Planning Application Reference:	20/00841/F
Location Of Development:	Barn And Land South West Of Cotefield Farm Church Street Bodicote
Proposed Development Details:	Erection of garage adjacent to approved dwelling and change of use of agricultural land to residential use

Comment for planning application 20/00841/F

DRAWING:  
**Proposed Elevations (Sheet 1 of 2)**

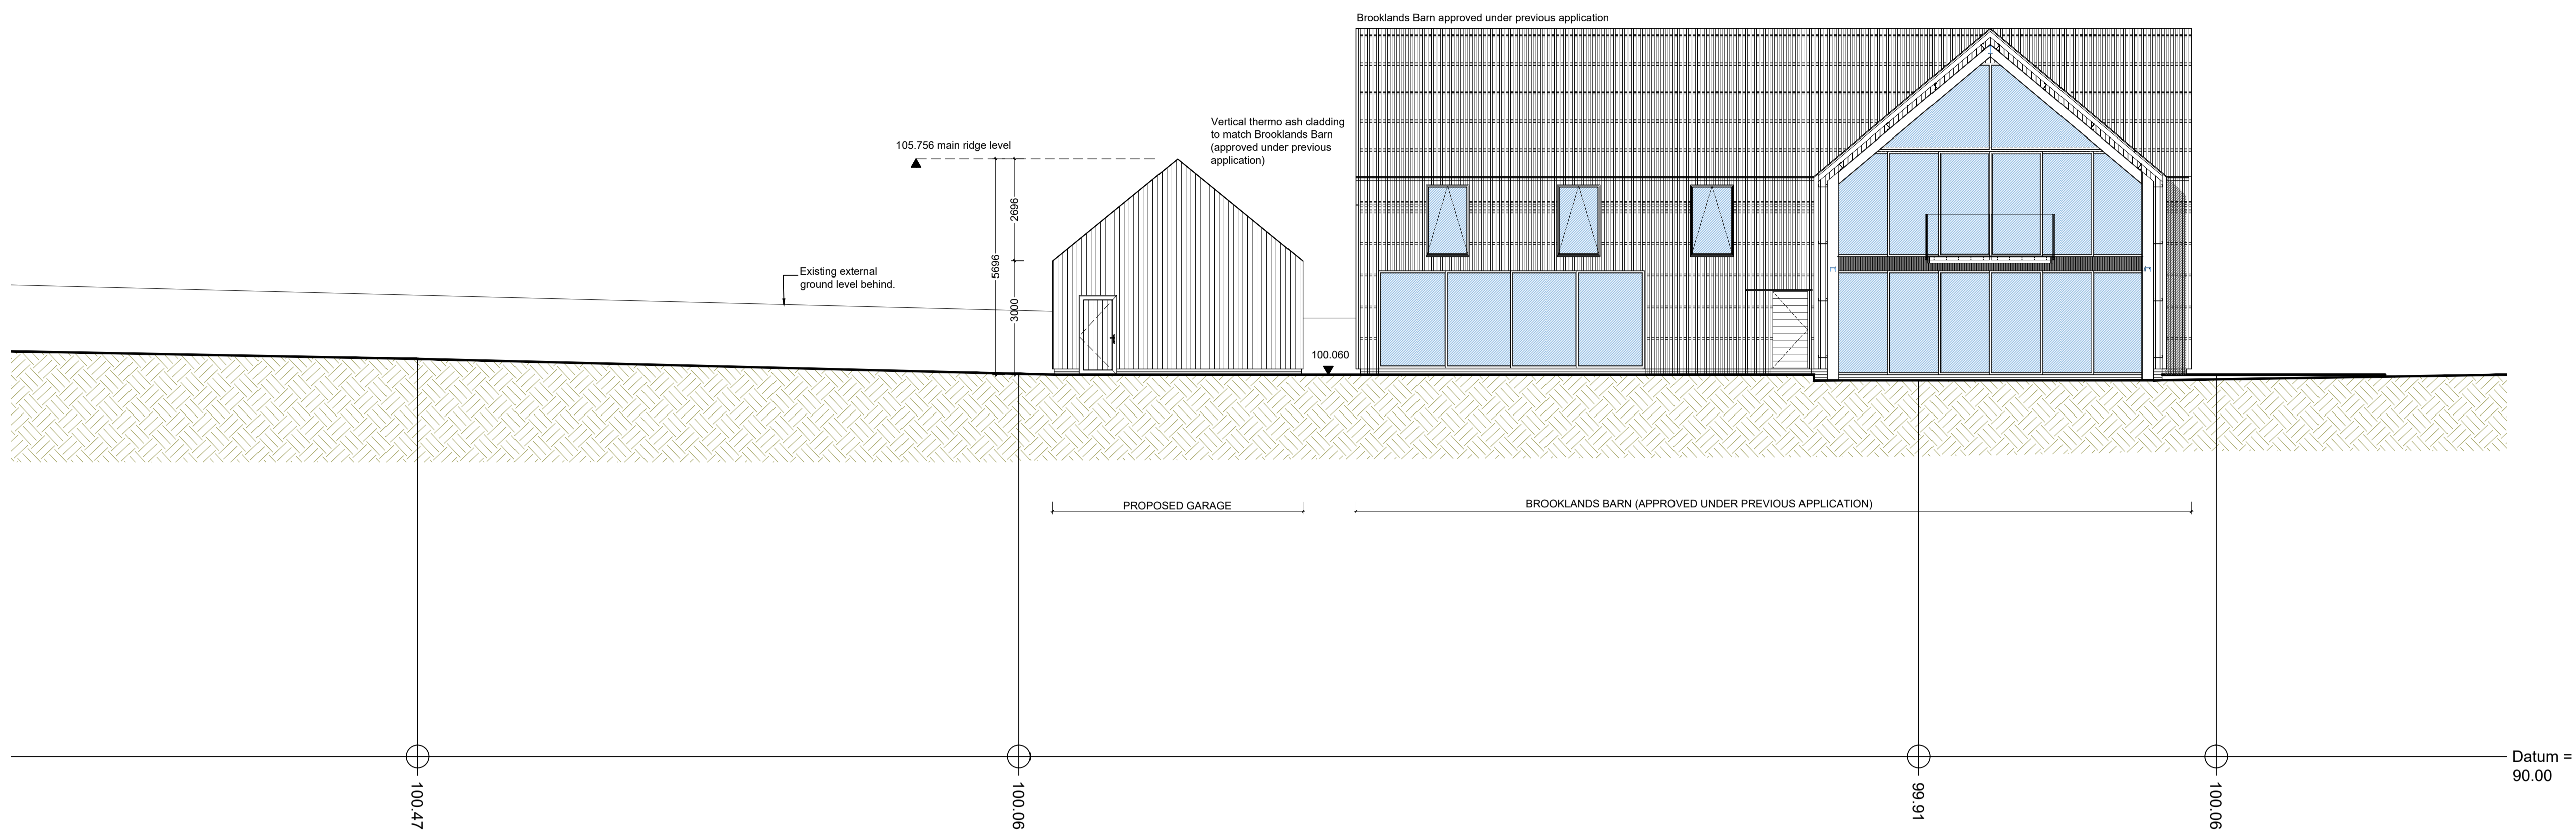
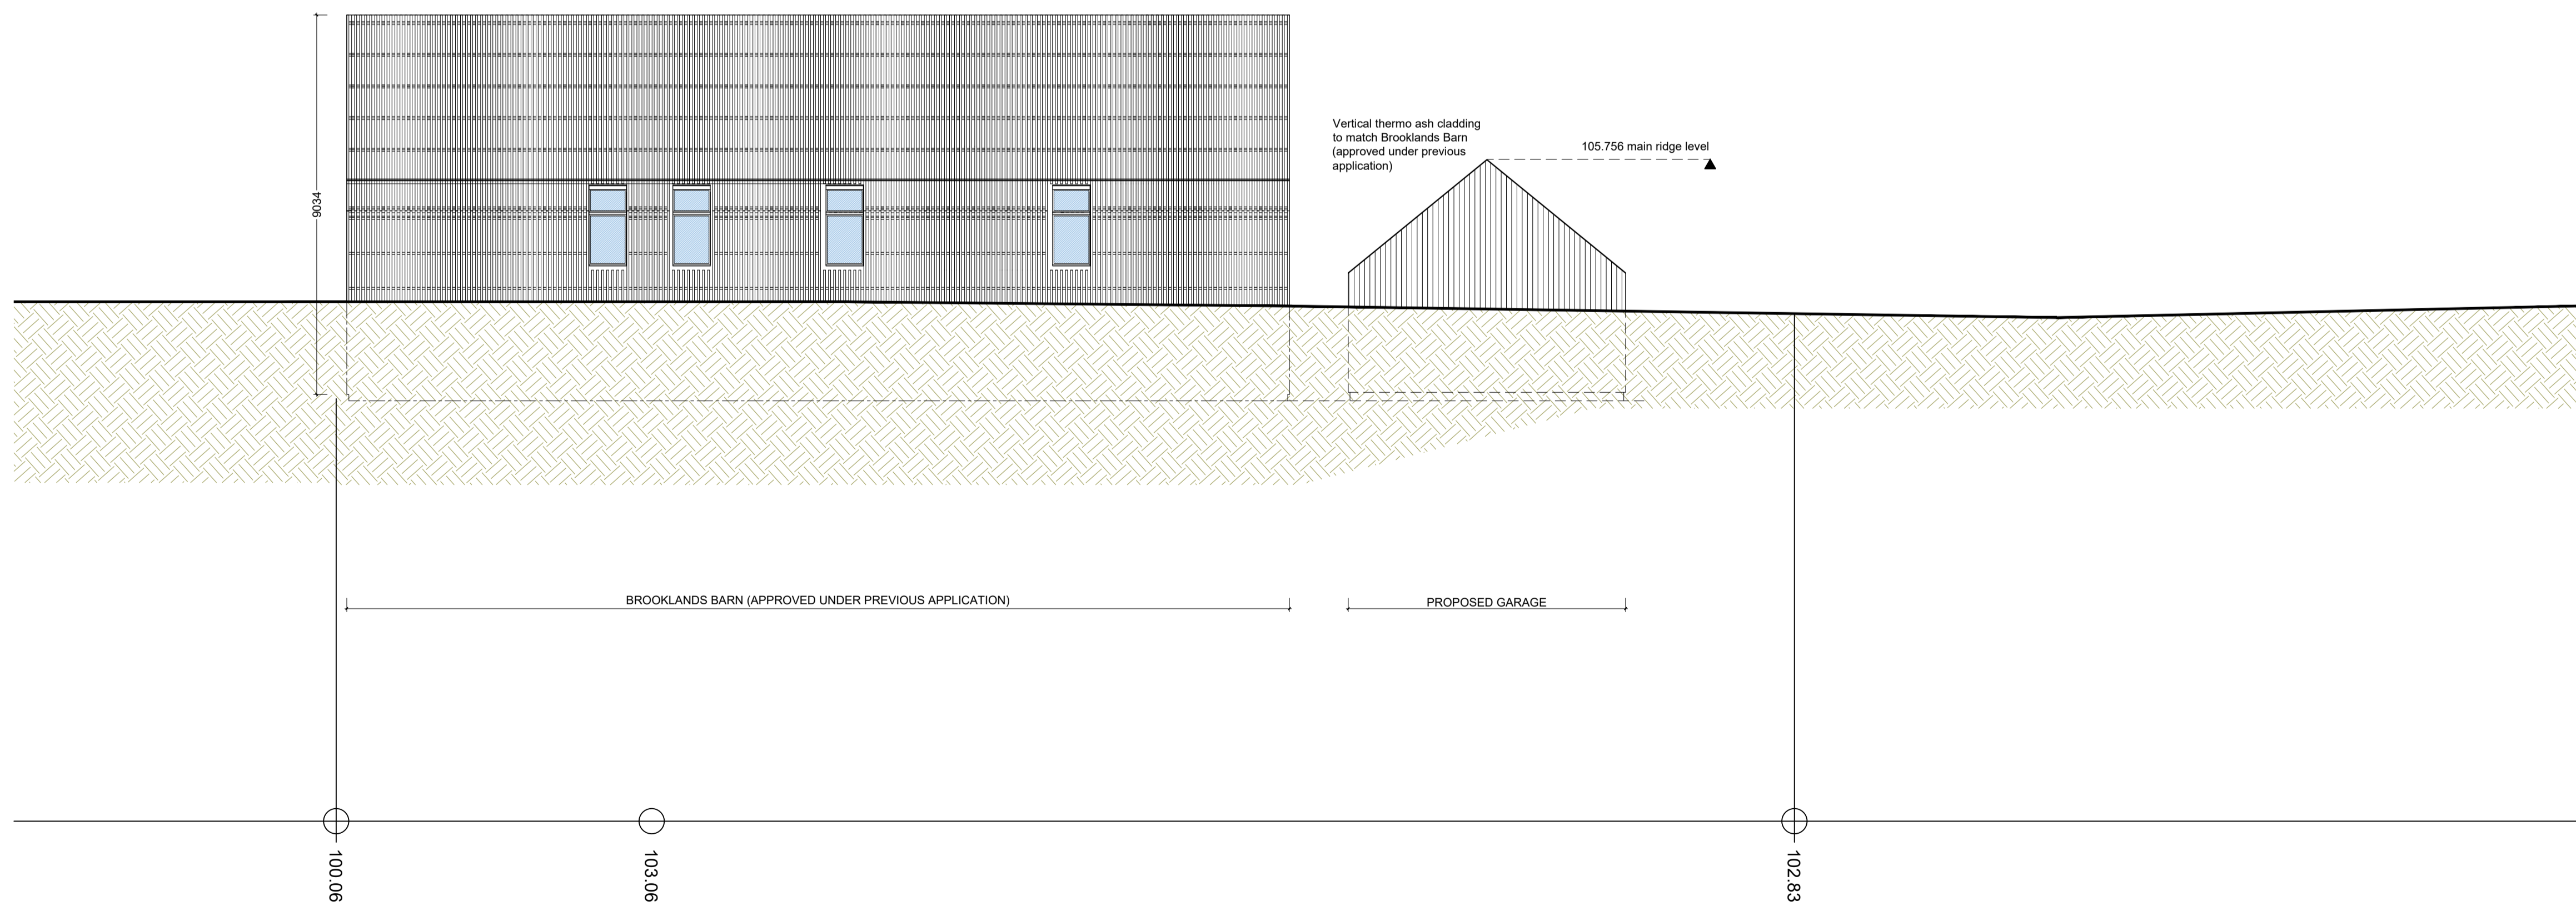
Application Number	<input type="text" value="20/00841/F"/>
Location	<input type="text" value="Barn And Land South West Of Cotefield Farm Church Street Bodicote"/>
Proposal	<input type="text" value="Erection of garage adjacent to approved dwelling and change of use of agricultural land to residential use"/>
Case Officer	<input type="text" value="Bob Neville"/>
Organisation Name	<input type="text" value="Paul Eagles & Sheila Adams"/>
Address	<input type="text" value="Bloxham Grove Farm, Bloxham Grove Road, Bloxham, Banbury, OX15 4LL"/>
Type of Comment	<input type="text" value="Objection"/>
Type	<input type="text" value="neighbour"/>
Comments	<input type="text" value="Further to our comments on planning application 19/01056/F which was refused; we can see no changes that would alter our objections, they are still relevant to this new/revised application. The proposed building has exactly the same dimensions with a few cosmetic variations that have little value"/>

Application Number	<input type="text" value="20/00841/F"/>
Location	<input type="text" value="Barn And Land South West Of Cotefield Farm Church Street Bodicote"/>
Proposal	<input type="text" value="Erection of garage adjacent to approved dwelling and change of use of agricultural land to residential use"/>
Case Officer	<input type="text" value="Bob Neville"/>
Organisation Name	<input type="text" value="Susan Weston"/>
Address	<input type="text" value="Bodicote Mill,Church Street,Bodicote,Banbury,OX15 4DR"/>
Type of Comment	<input type="text" value="Objection"/>
Type	<input type="text" value="neighbour"/>
Comments	<input type="text" value="I have reviewed the plan and am not convinced that it has changed materially. It is still for 5/6 bay garage including a tractor and three parking spaces. This seems excessive for a single occupancy residential house. it has moved closer to the main house but is still imposing."/>

Application Number	<input type="text" value="20/00841/F"/>
Location	<input type="text" value="Barn And Land South West Of Cotefield Farm Church Street Bodicote"/>
Proposal	<input type="text" value="Erection of garage adjacent to approved dwelling and change of use of agricultural land to residential use"/>
Case Officer	<input type="text" value="Bob Neville"/>
Organisation Name	<input type="text" value="Michael Weston"/>
Address	<input type="text" value="Bodicote Mill,Church Street,Bodicote,Banbury,OX15 4DR"/>
Type of Comment	<input type="text" value="Objection"/>
Type	<input type="text" value="neighbour"/>
Comments	<input type="text" value="Dear Sir, I object as the size of the garage is exactly the same as the last application which was refused. And my objection remains on the same basis. I think that a garage of five vehicles and three parking bays is excessive for a single occupancy residential property. Why is a large agricultural vehicle needed in a residential property? As a result the proposed building increases significantly the residential footprint and is unnecessarily large and imposing in my view. Thank you Michael Weston"/>

Application Number	20/00841/F
Location	Barn And Land South West Of Cotefield Farm Church Street Bodicote
Proposal	Erection of garage adjacent to approved dwelling and change of use of agricultural land to residential use
Case Officer	Bob Neville
Organisation Name	Susan Weston
Address	Bodicote Mill, Church Street, Bodicote, Banbury, OX15 4DR
Type of Comment	Objection
Type	neighbour
Comments	Dear Sir, I have already objected to this application and would like to add one or two more comments. I believe it should be underlined that this is for exactly the same size garage as previously applied for and which following consultation was rejected. A five bay garage and three parking bays is in my view excessive for a single occupancy residential property. The allocation of significant space for agricultural equipment is not appropriate for a residential property. And as a result the proposed garage significantly increases the residential footprint. Susan Weston
